August 30, 2016

## **Addition to Bayside Bowl Portland, Maine**

### **Plan Revision Narrative**

ASK
05A

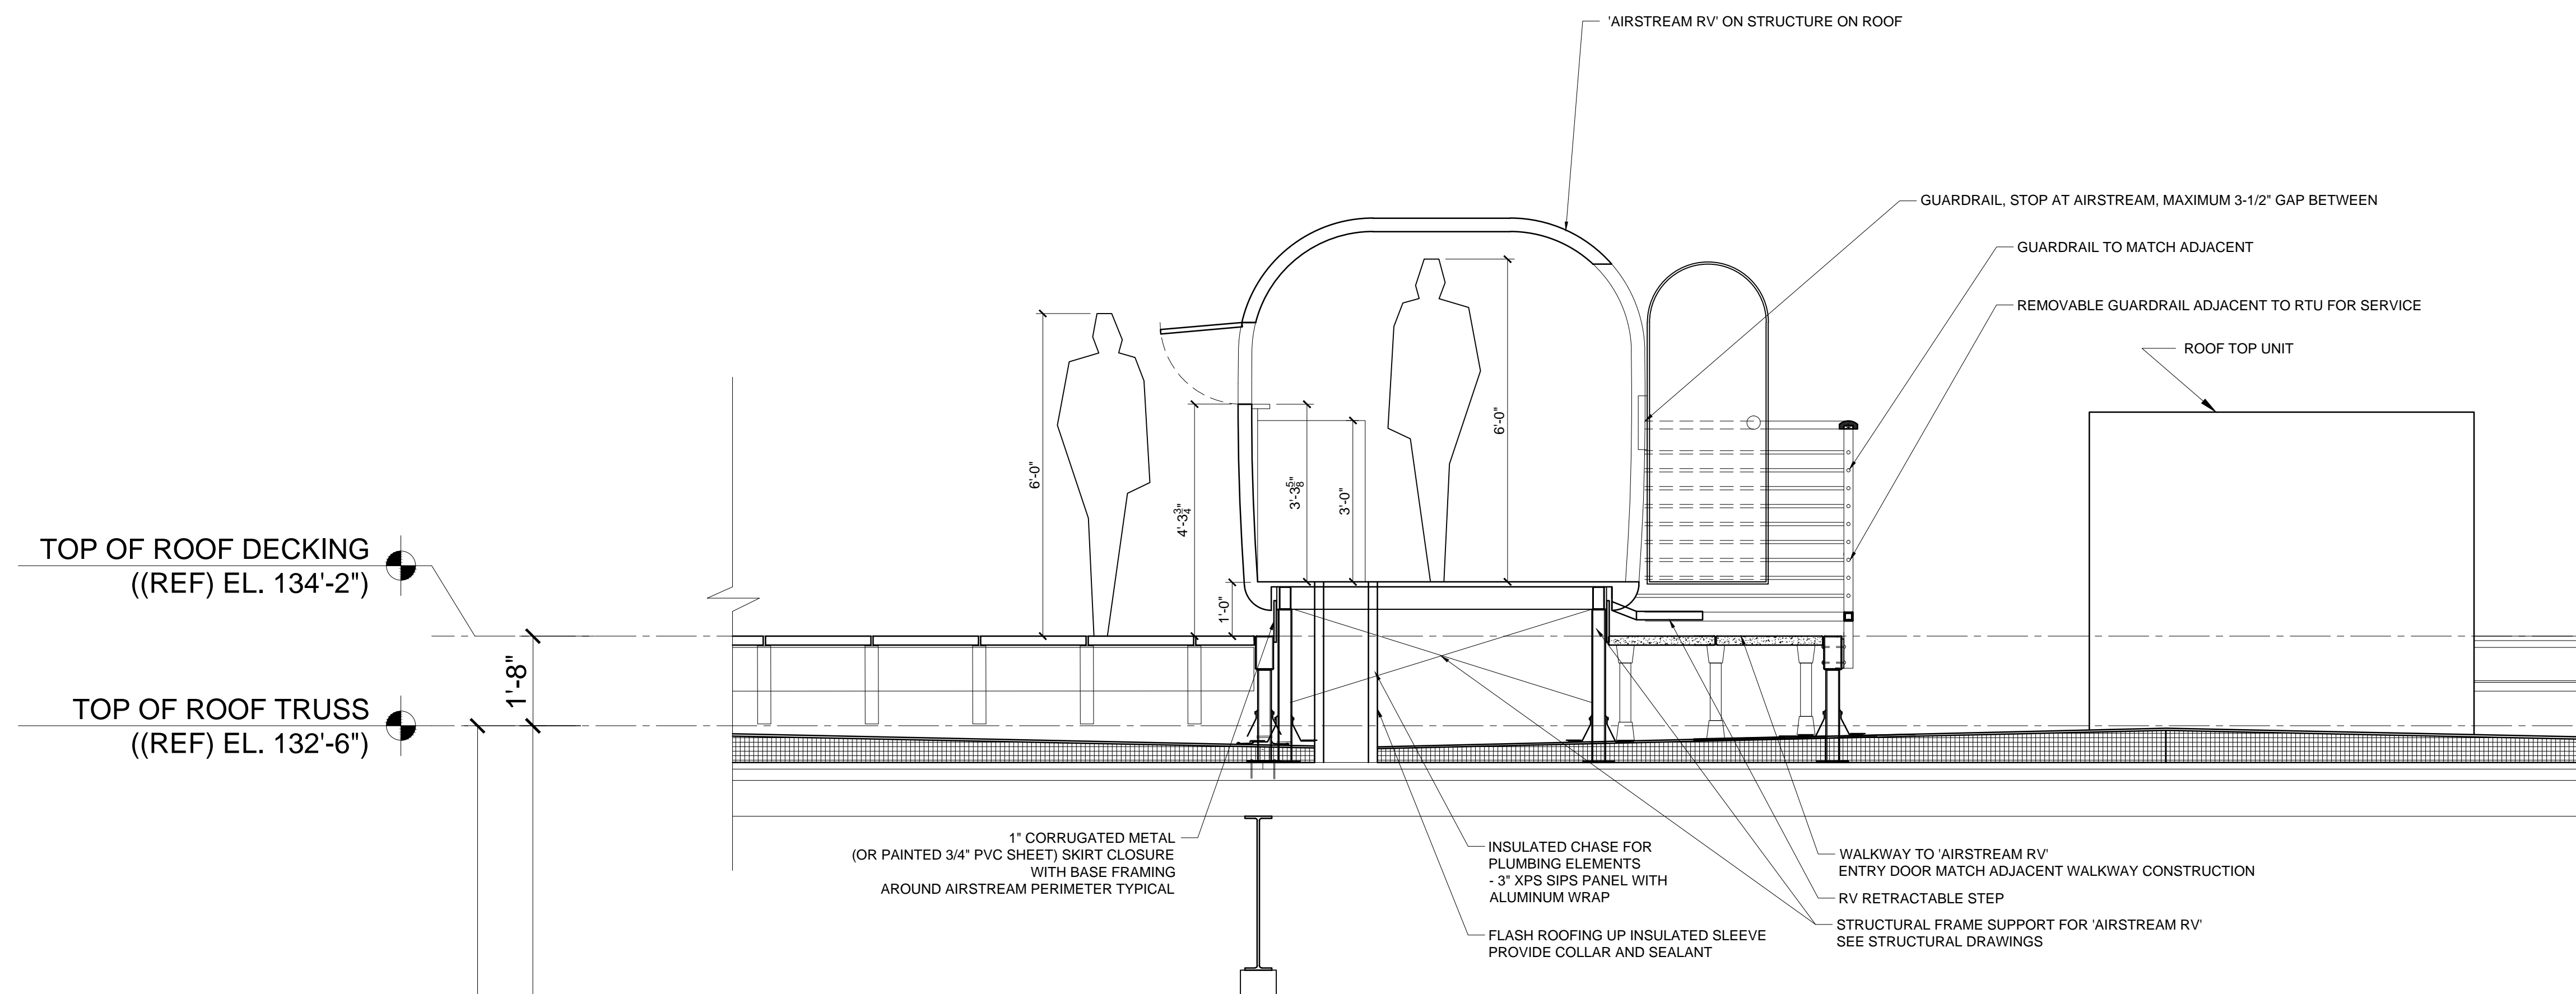
- 5.) Drawing ASK-05 and ASK-05A, we have added an 'Airstream RV' on the roof, this will be modified so food can be served from it to the patrons on the roof deck. We are finalizing the equipment layout within the RV and will submit that additional information in the coming weeks.

1 PLATFORM FLOOR PLAN
1/4" = 1'-0"

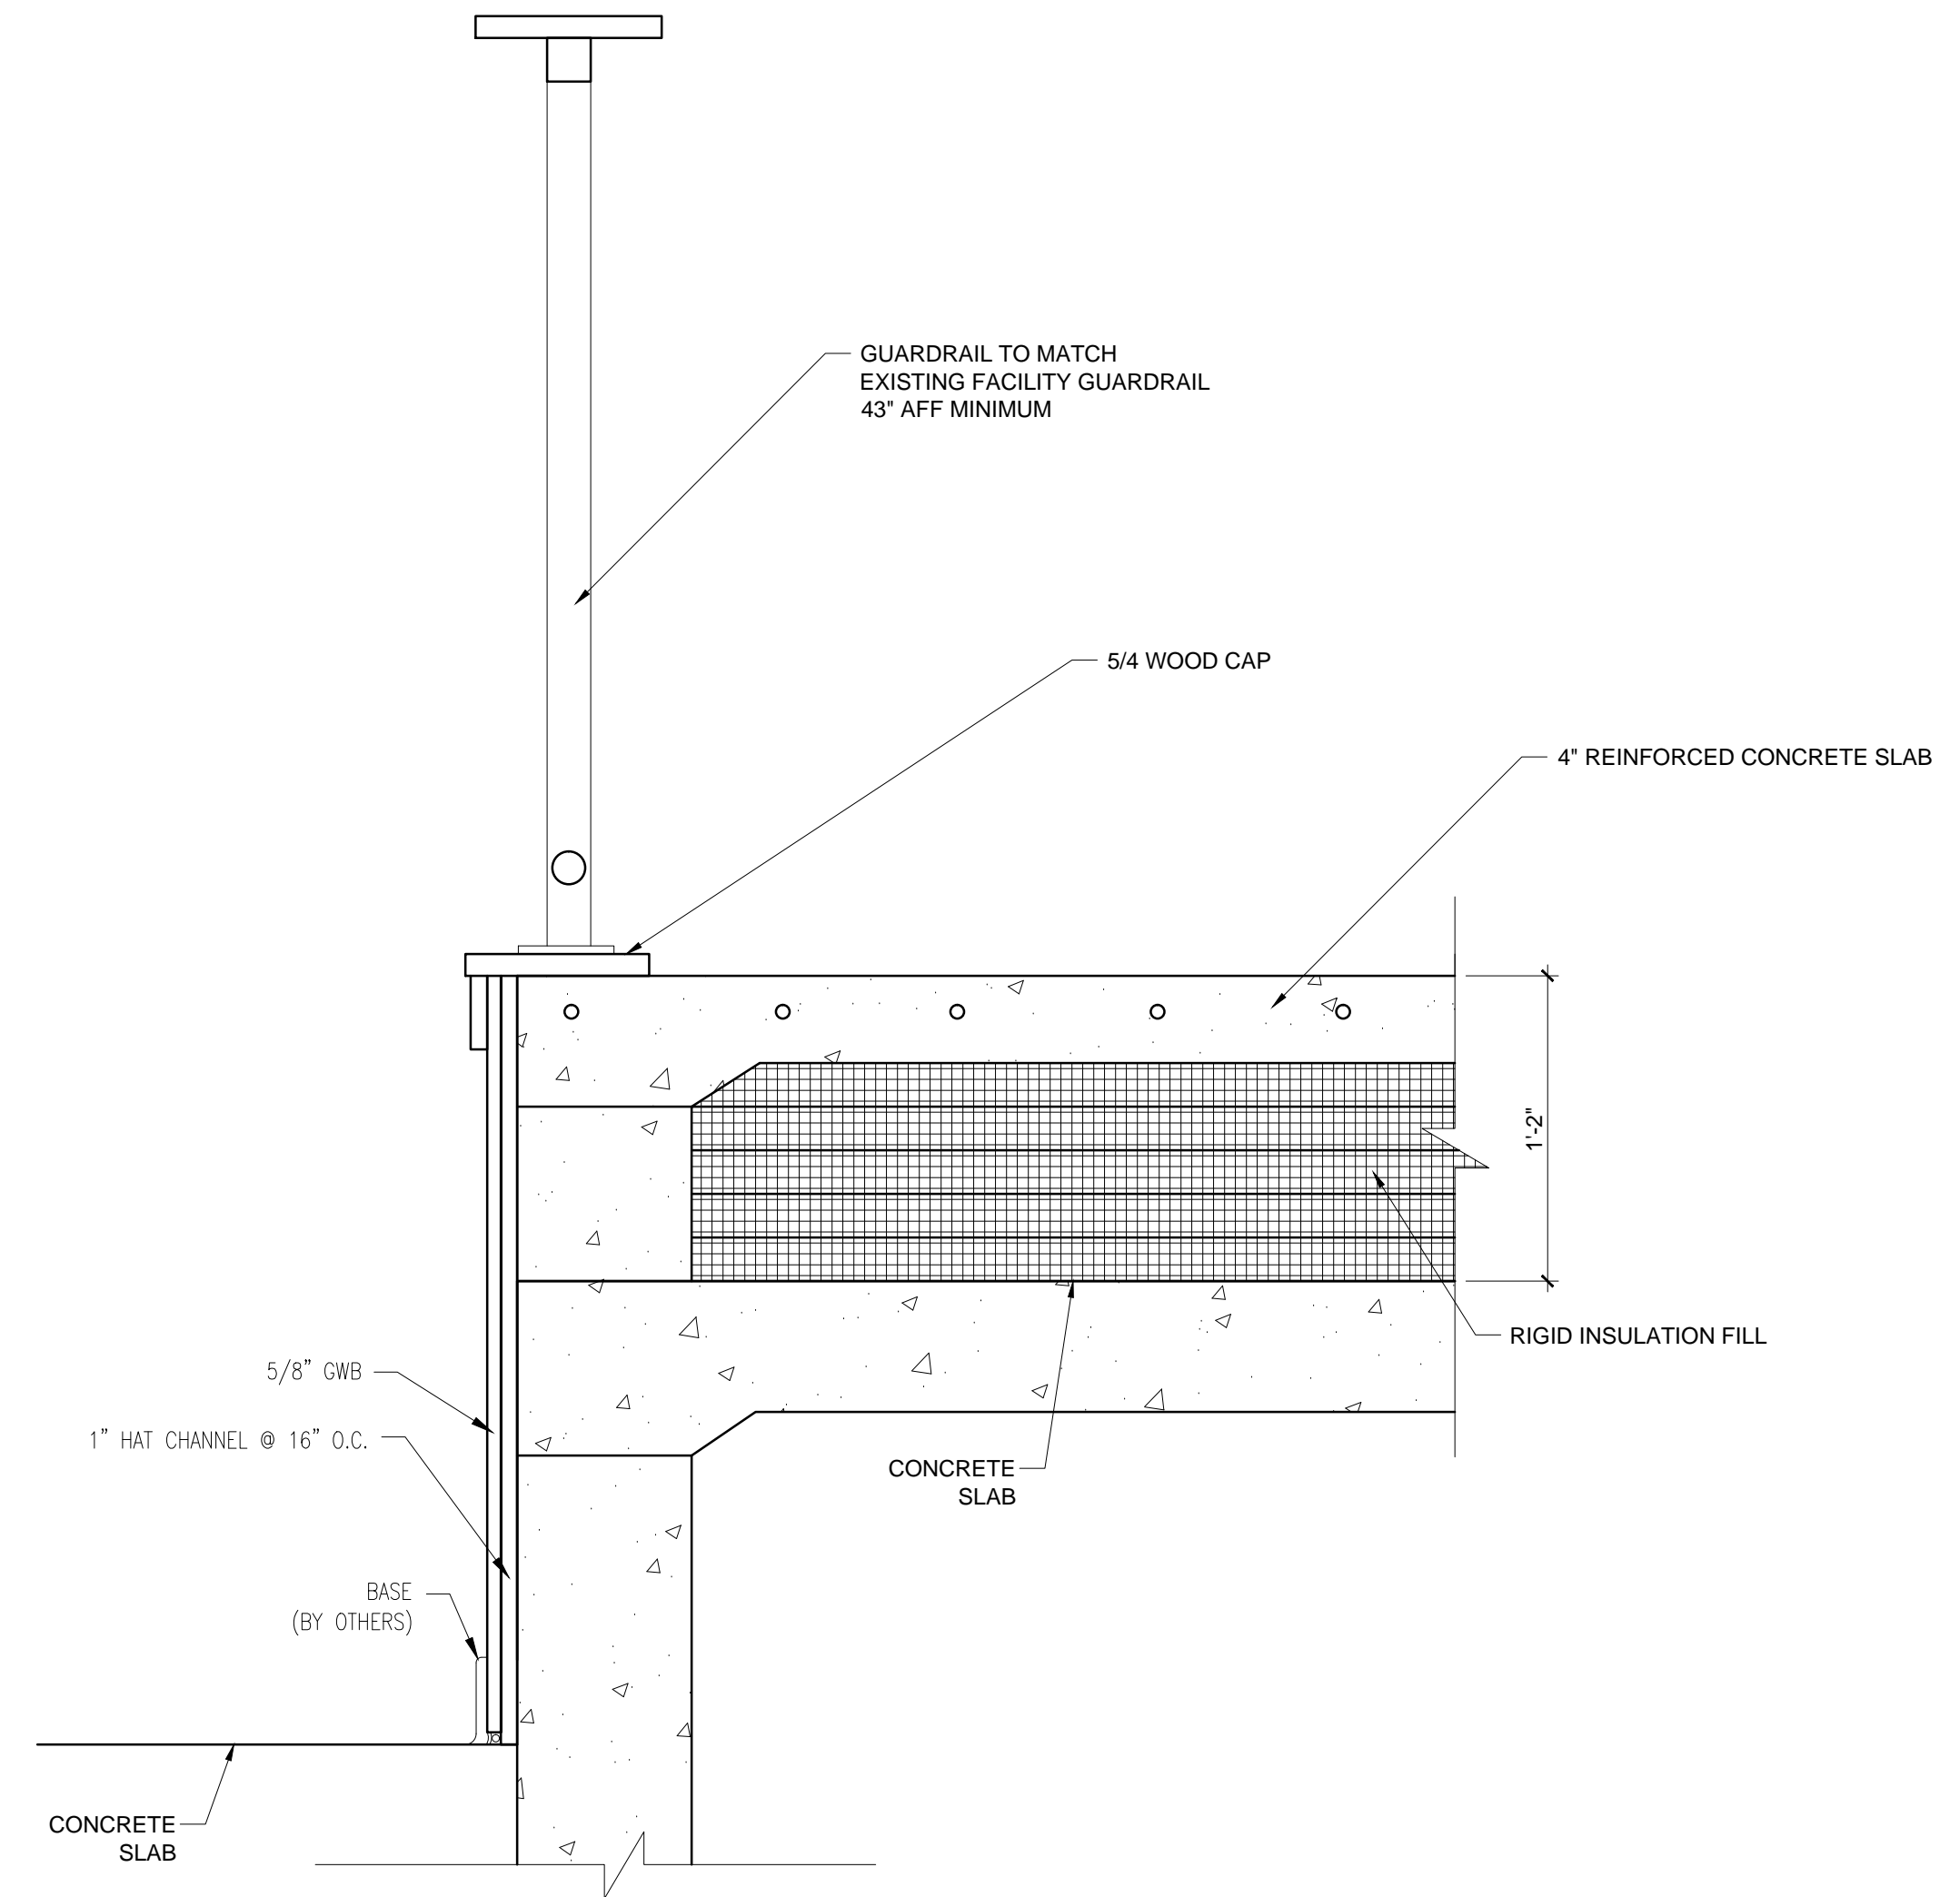
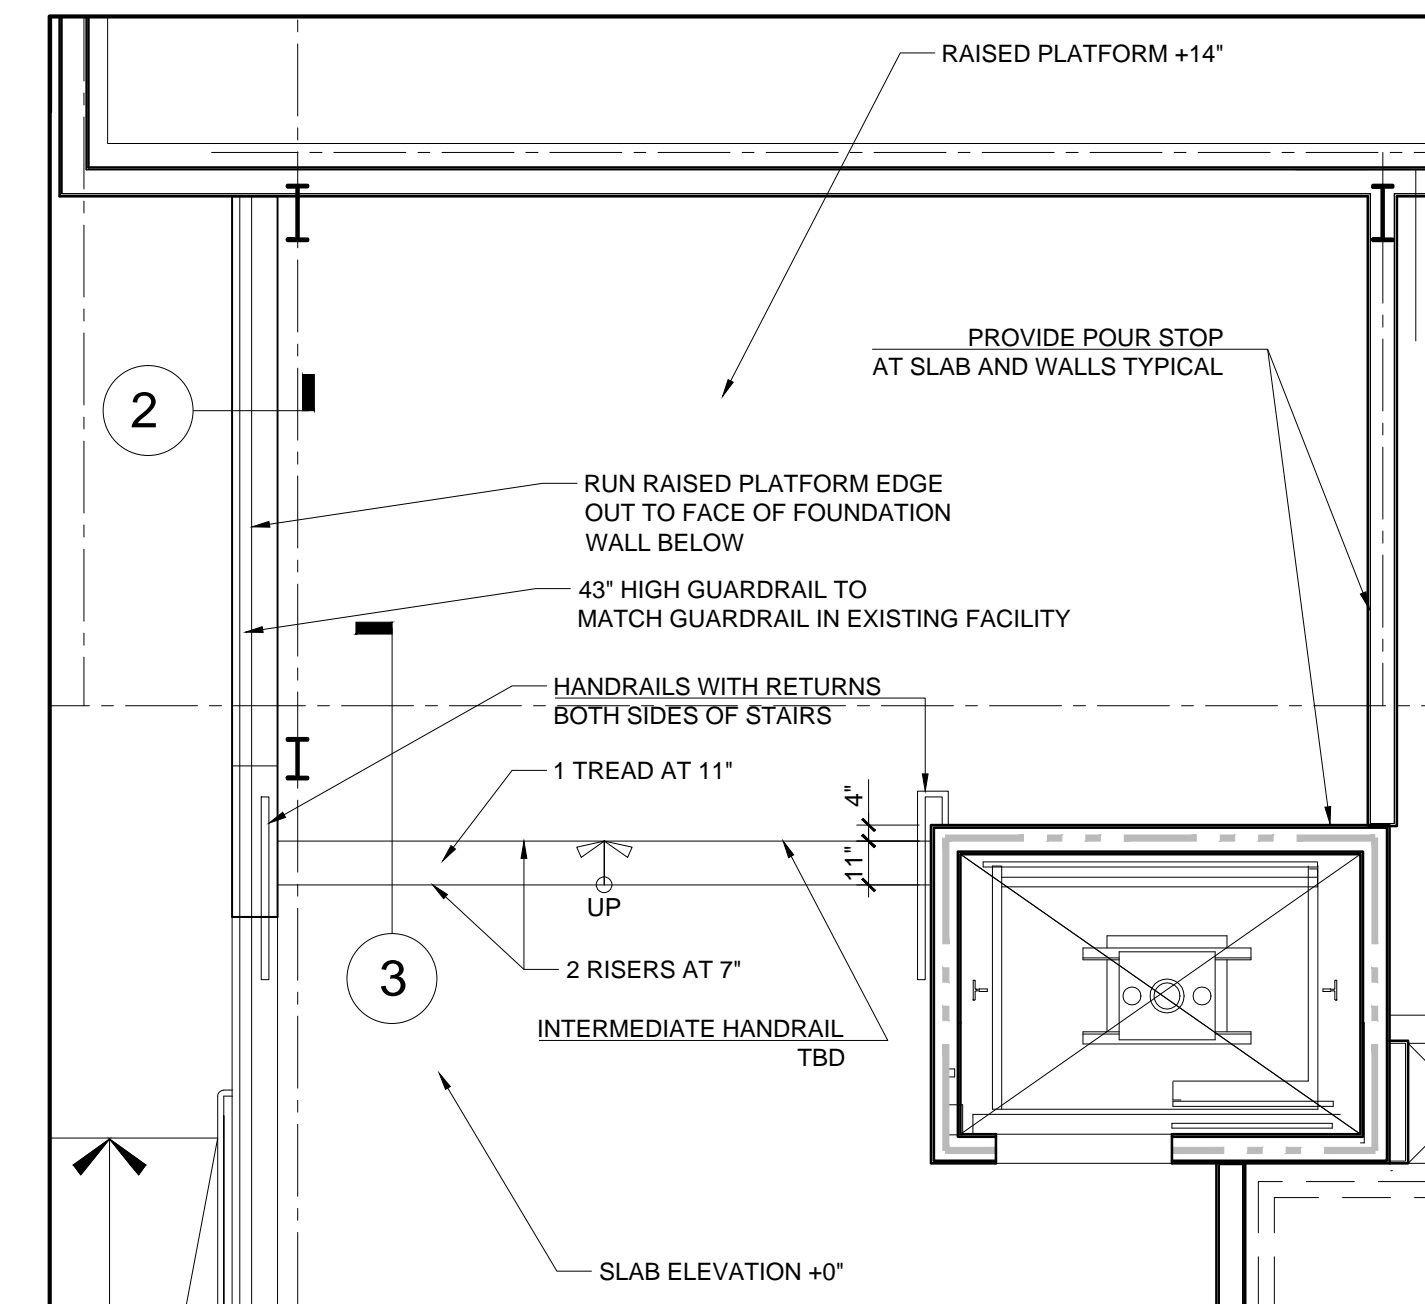
- 1.) Drawing A1-1 and ASK-03, we relocated the Pro Shop and reconfigured the coatroom into an area for a small arcade
- 2.) Drawing A1-1 and ASK-06, we relocated the first floor bathrooms toward Stair 114 and raised a section of the floor at the previous bathroom location to provide a raised seating area.
